From: Daun Johnson <Daun.Johnson@arun.gov.uk>
Sent: 17 September 2020 16:41
To: Stephen Thorpe [REDACTED]
Cc: Nicola Spencer <Nicola.Spencer@arun.gov.uk>; Nicola Moore <Nicola.Moore@arun.gov.uk>
Subject: BR/222/20/PD Gordon House, Queensway, Bognor Regis

I have set up the Prior Notification under Part 20, Class AA today. The reference number is above.

Drawing
Existing 3rd Floor Plan

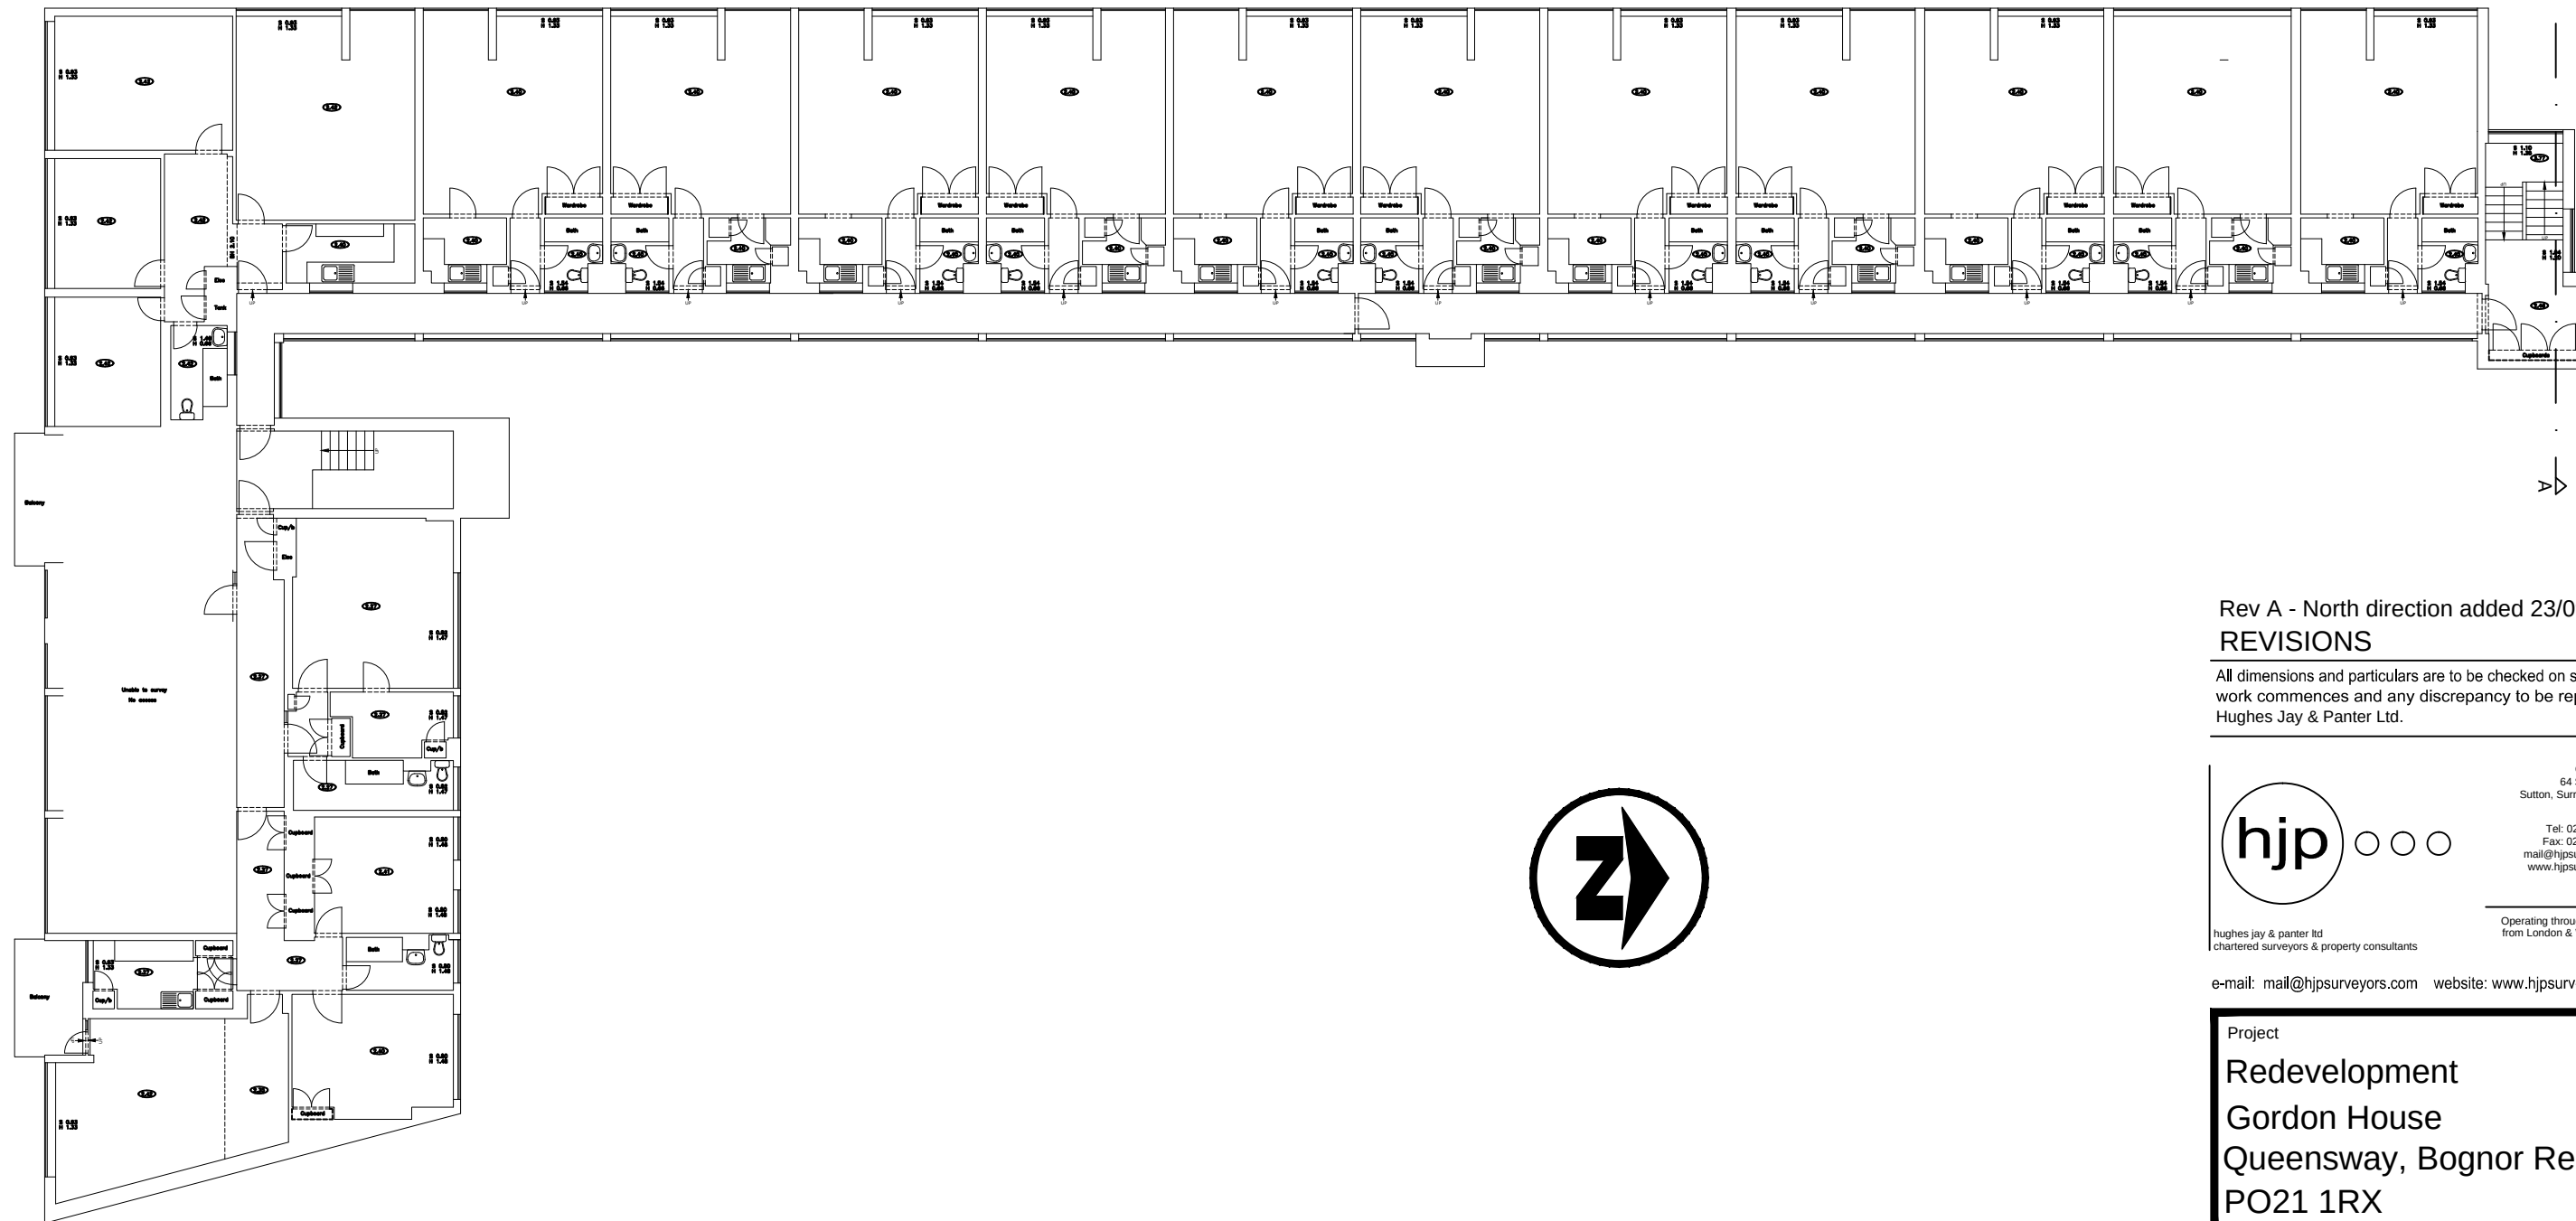
- A fee of £5678 is due for the application, which can be paid at www.arun.gov.uk, quoting reference BR/222/20/PD
- On all floor plans, please provide a North point
- Please provide a CIL Form
- The proposed North elevation plan shows the elevation as existing. Please amend accordingly
- Please confirm the dimensions of all windows and doors on the floor plans. If the all the windows and doors are the same dimensions, an email to confirm the dimensions is fine
- Please confirm what the circled 2.4 is on the existing floor plans

I can confirm the 2.4 circled on the existing floor plans is the floor to ceiling height.
